February 9, 2022

TO: Johnston Architects

SUBJECT: Design Comment Response
Mercer Island Mixed-Use Development
Mercer Island, WA

This letter and the attached documents represent our comment response for Geopier® soil reinforcement at the site of the Mercer Island Mixed-Use development located in Mercer Island, WA.

10

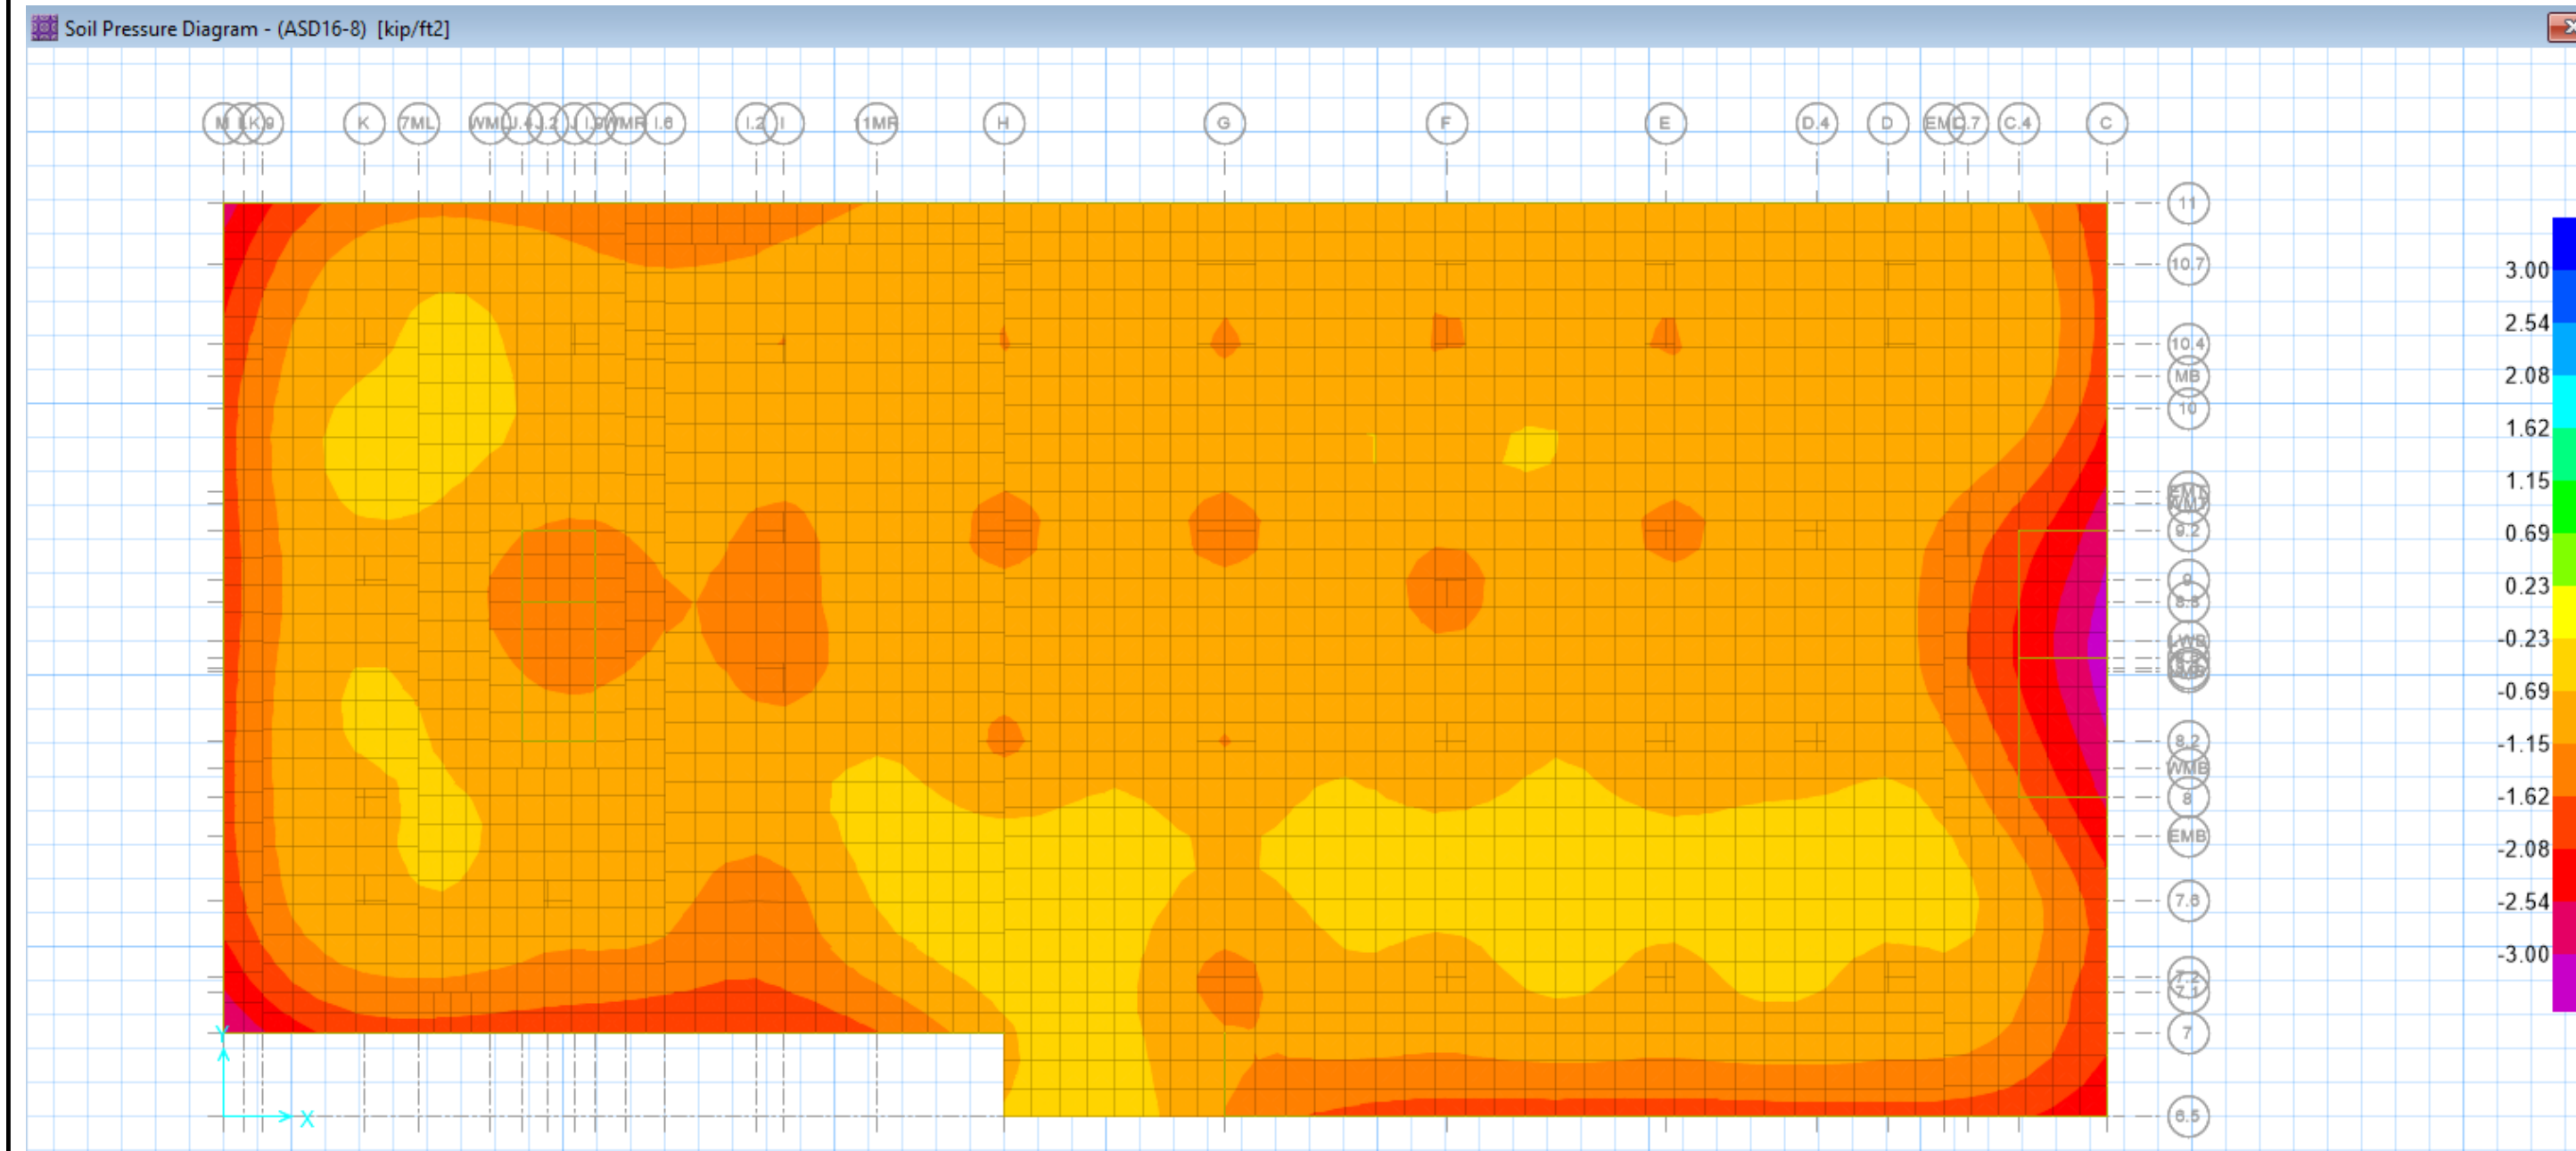
- We are using a stronger stiffness in the lower 2 feet because it is assumed the bottom 2 feet is into the stiffer transition material into the competent soil. It should be noted that the Hart Crowser depth to competent bearing soils only goes as deep as Elevation 63 feet so our modelling is conservative, refer to Figure 10 of the geotechnical report for competent soil contours.
